**From:** Martyn White  
**Sent:** 13 March 2019 11:29  
**To:** Planning.Responses  
**Cc:** Simon Davis  
**Subject:** BR/326/18/PL

**The royal Hotel - BR/326/18/PL**

### **Description of proposal**

TYPICAL WINDOW DETAIL

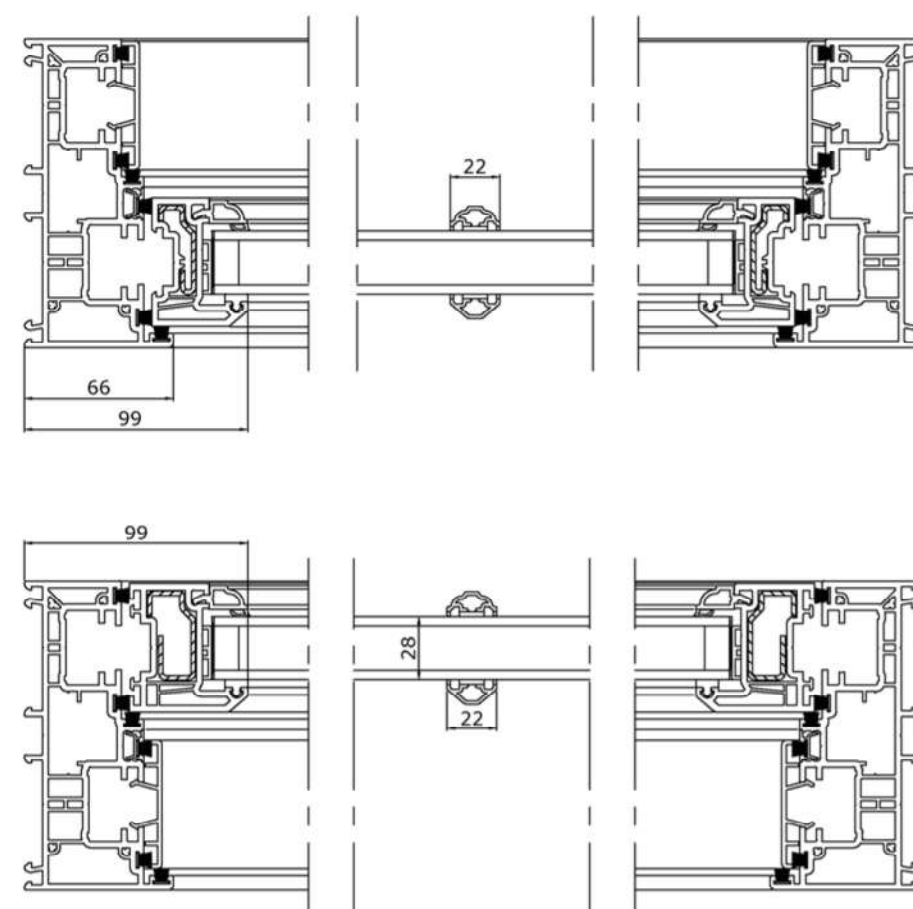
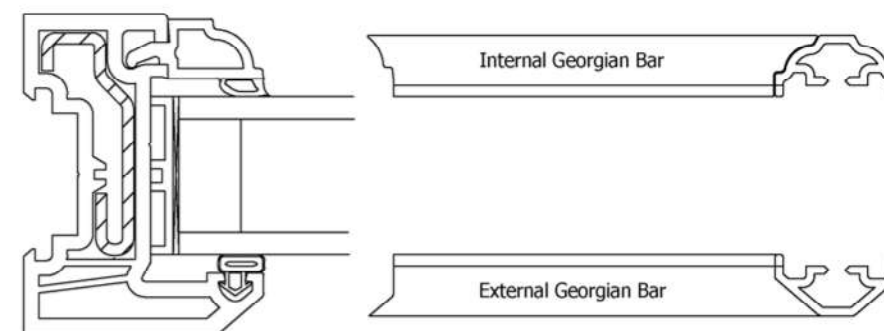
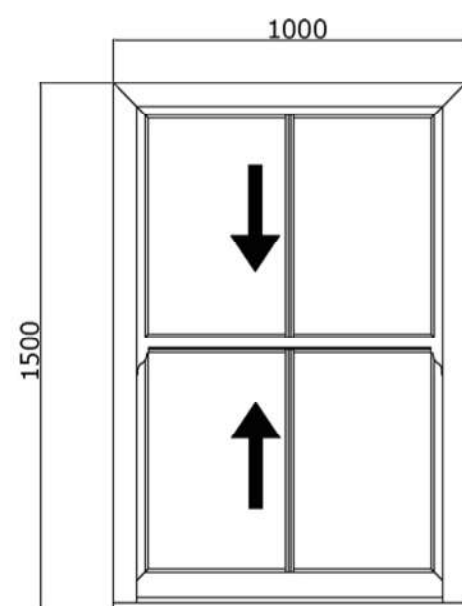
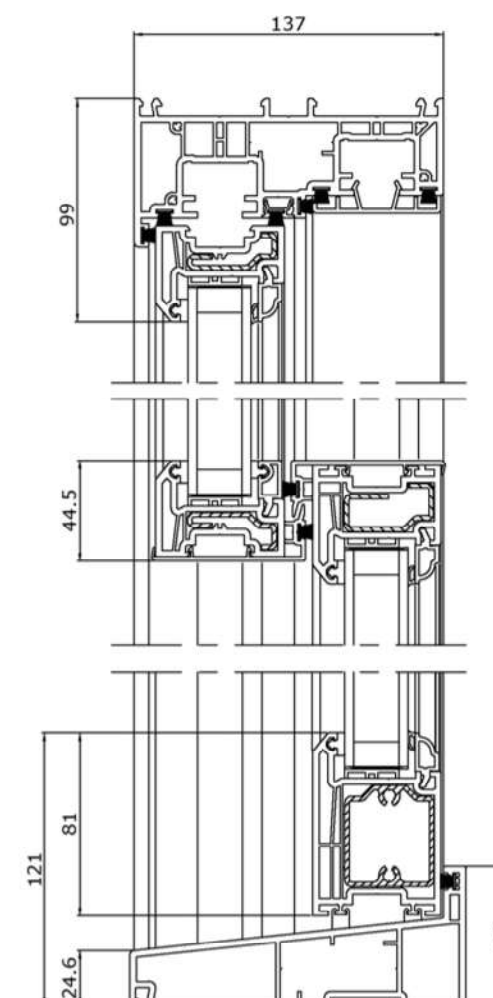
The fenestration of the building will have a significant impact upon the success of the works, and should closely reflect the remaining traditional windows. It is considered that the best approach would be to use sliding sash windows. The windows should also be such that the design/measurements closely reflect the existing, remaining traditional windows.

It is suggested that details of all of the windows, railings and external paint colours be supplied prior to works commencing in order to ensure that they reflect the traditional character of the conservation area. .
